17 March 2016

Our Ref: 2016/124994  
File No: R/2015/21/A  
Your Ref: SSD 7080

**RE: Exhibition of proposed mixed use residential and retail development at 80-88 Regent Street, Redfern (SSD 7080) - OBJECTION**

Job No.	Drawing No.	Revision
5359	DA-0501	/ 6

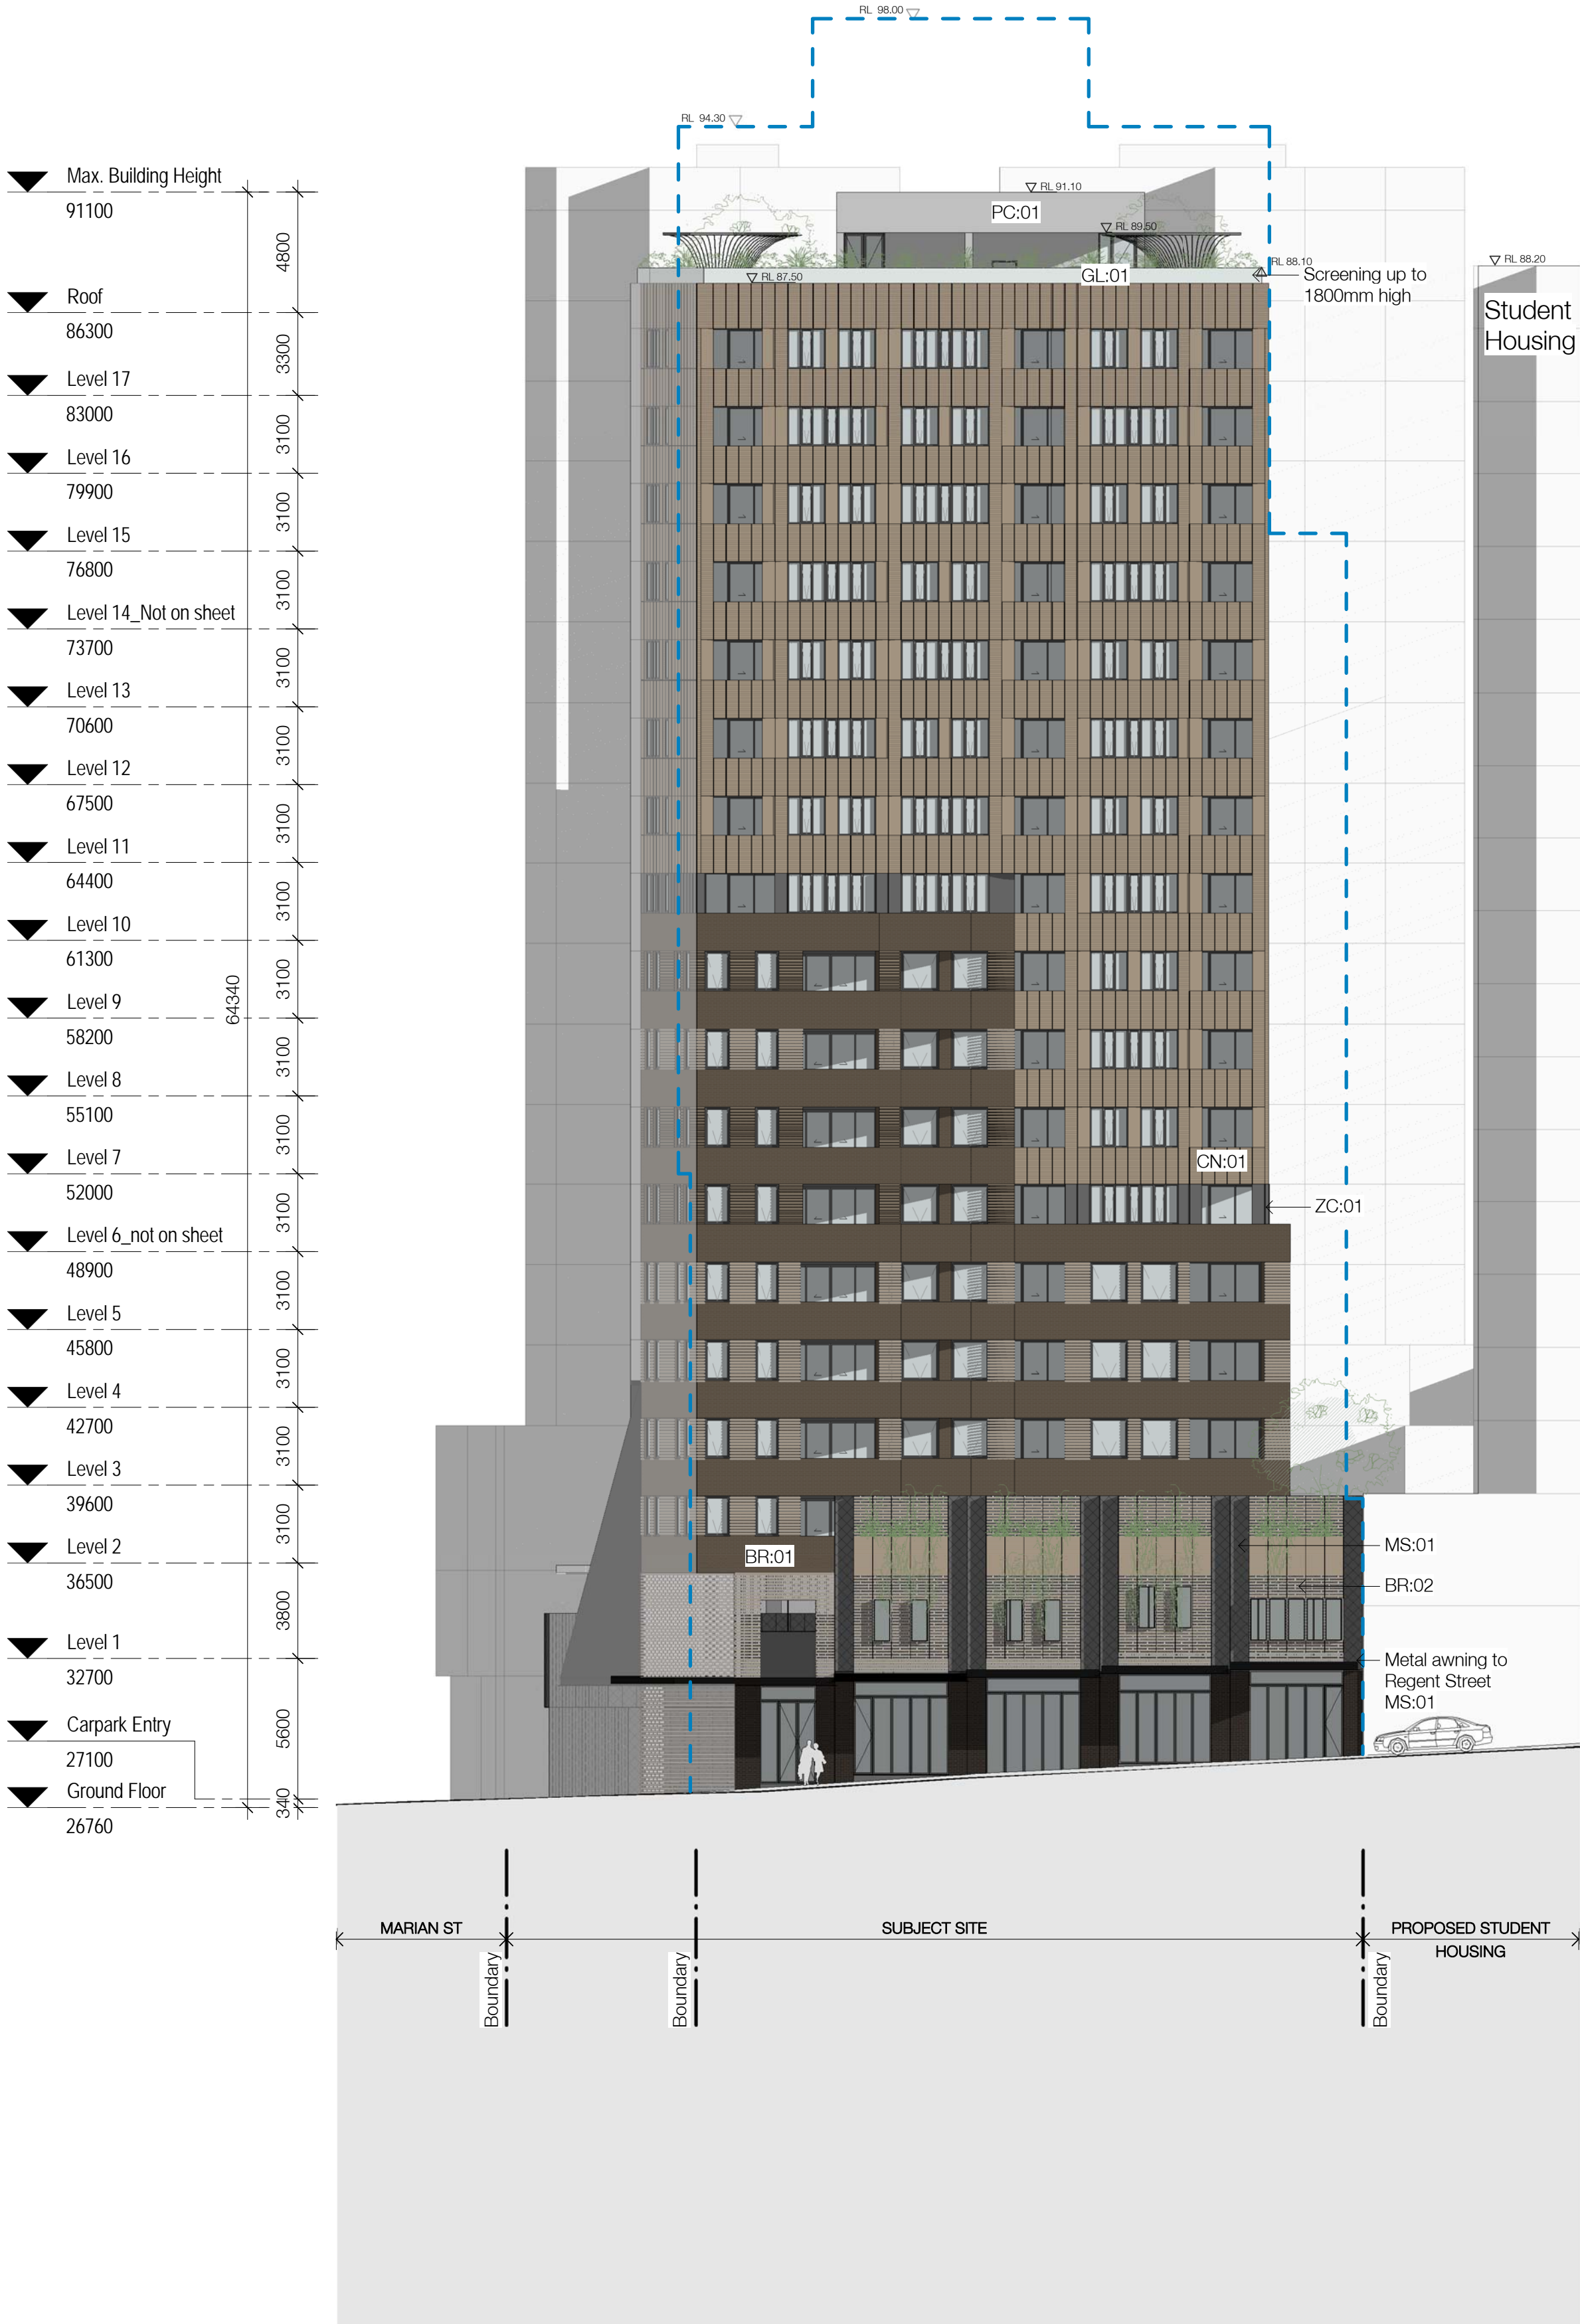
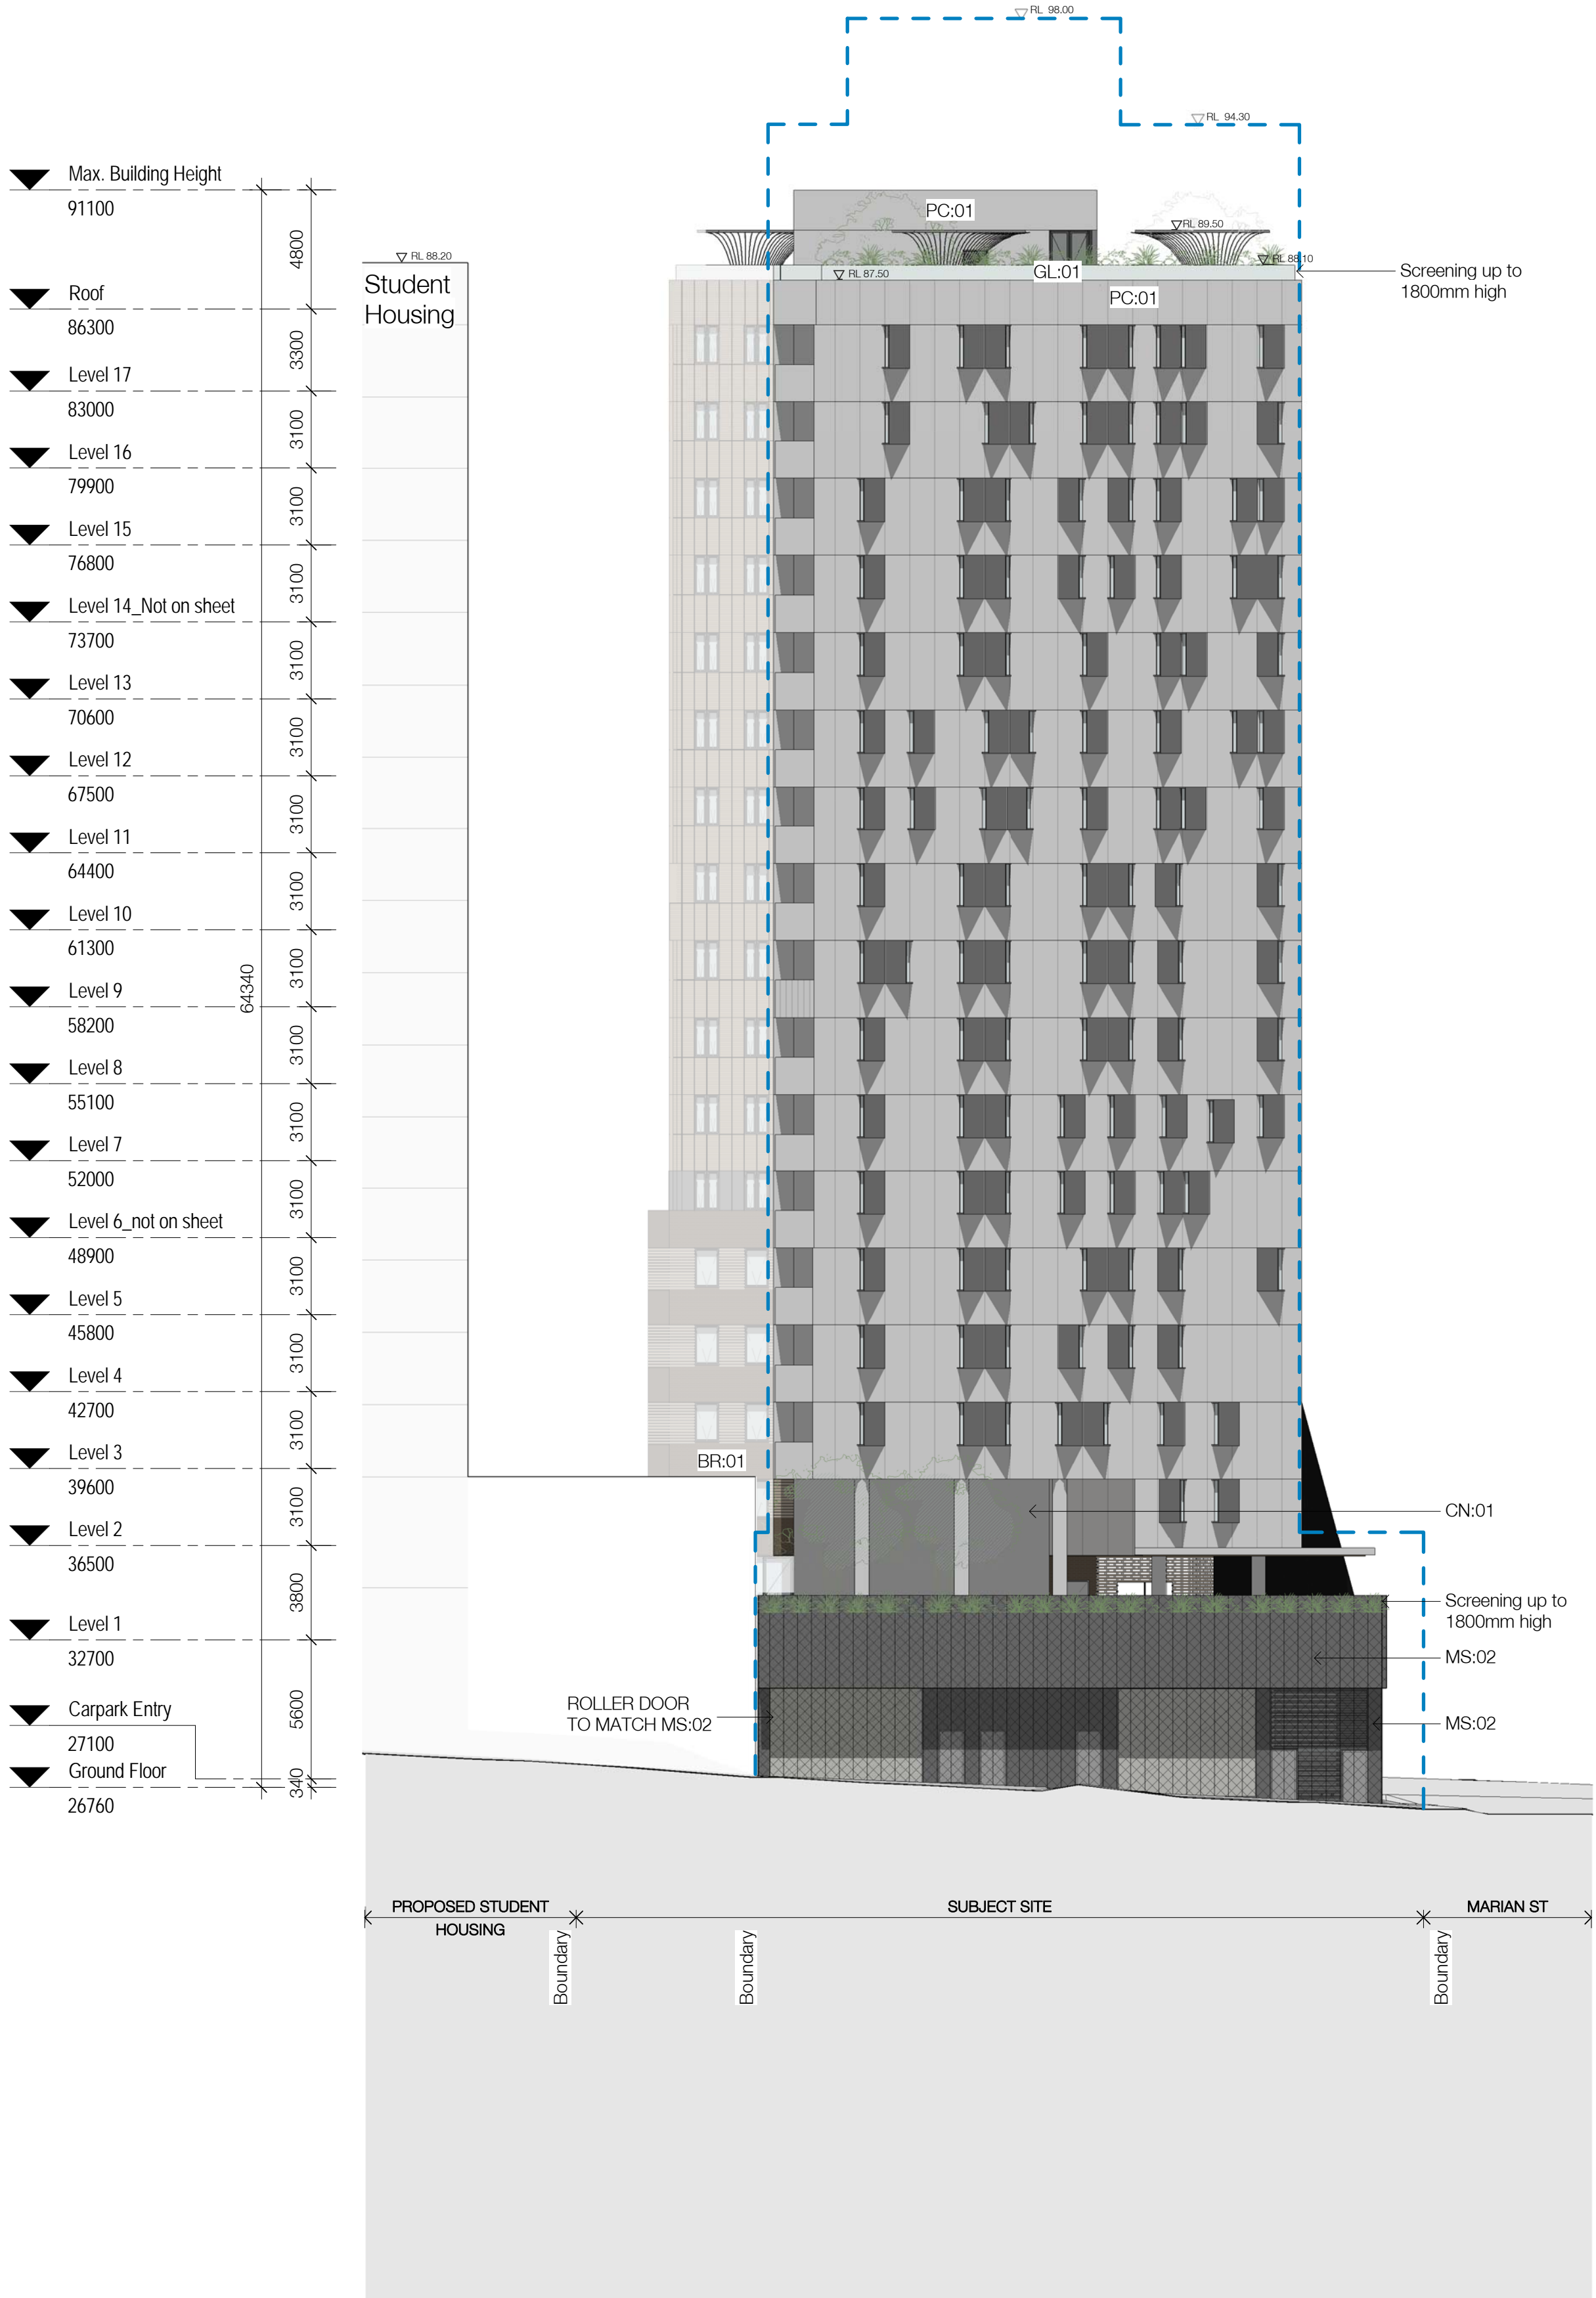
13. Marian Street setback - the controls for the site suggest an upper level setback to Marian Street above the street frontage height, however the proposal is built to the boundary at the corner of Marian Street and Regent Street for 53% of the building frontage of Marian Street. The remainder of the building frontage has an upper level setback that varies due to the trapezoidal shape of the site and ranges from 1.2m to 4m.

- Investigate the rationale for the 800mm setback on adjoining properties. An 800mm setback to William Lane that matches that of the student housing proposed should be provided for Ground Level and Level 1 at a minimum. This setback should be clear of any structure and building elements.
- The reduced upper level Regent Street setbacks for Levels 15 to upper mezzanine are acceptable, subject to the proposal demonstrating that there are no additional overshadowing and view loss impacts as a result of this non-compliance with the upper level setback control.
- A setback from the podium to upper levels should be provided, as envisaged in the controls.

- The scale, form and height of the podium are to be revised to respect the local character, topography and streetscape. The new building should set back from the podium at the corner of Marian and Regent Streets, in accordance with the controls. The podium design should make reference to the prominent features of traditional shopfronts, such as solidness of the first level and presence of top parapets.

03. Original (Exhibited) DA non-compliant tower and podium setbacks

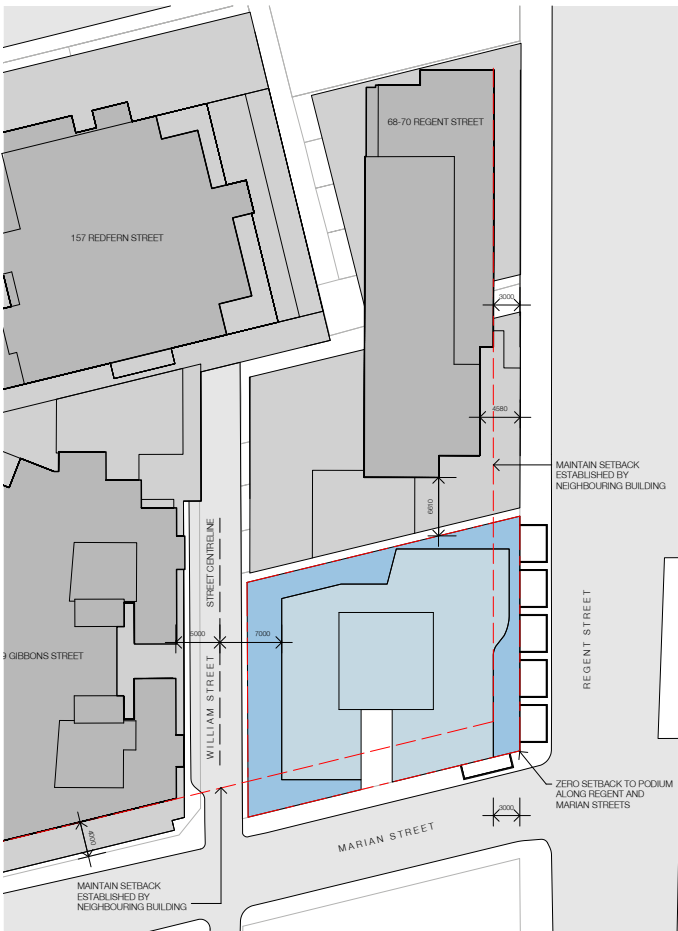
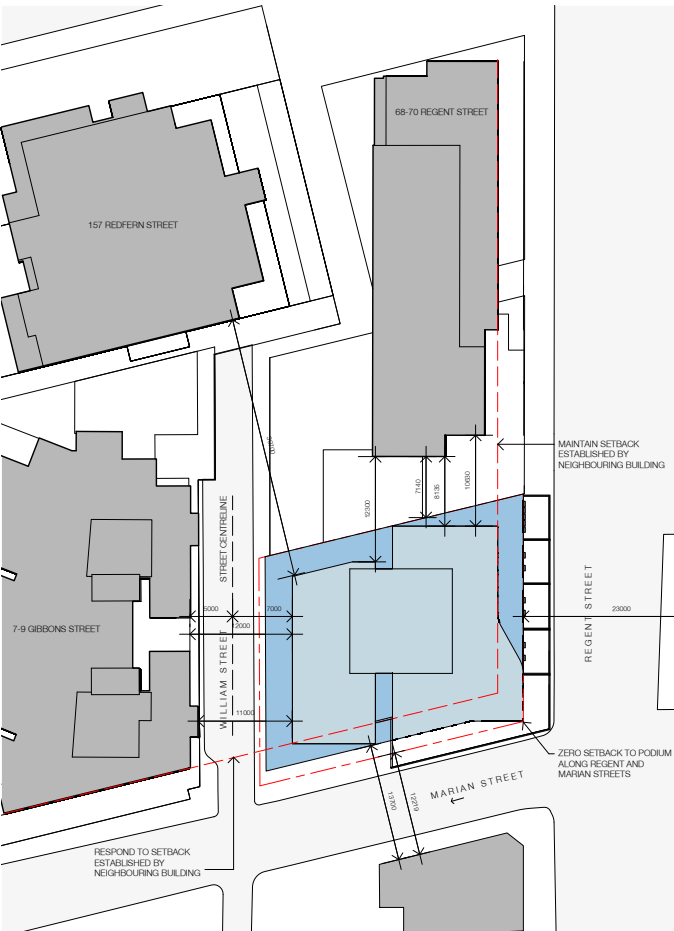
19. The new podium proposes a series of five, large, high arches, which appear to be an interpretation of the existing 5 terrace buildings.
20. The podium will result in a contemporary but contrasting appearance. The large arches and glazing are not in keeping with local character, in particular the fine

grained shopfronts on Regent Street and Botany Road. The form of large arches has no provenance in the local area and the scale and height of the podium does not complement the retained facades and remaining commercial buildings that surround the site. The podium also appears to be under scaled to the proposed new building, the zero setback from Marian Street contributes to the discord.
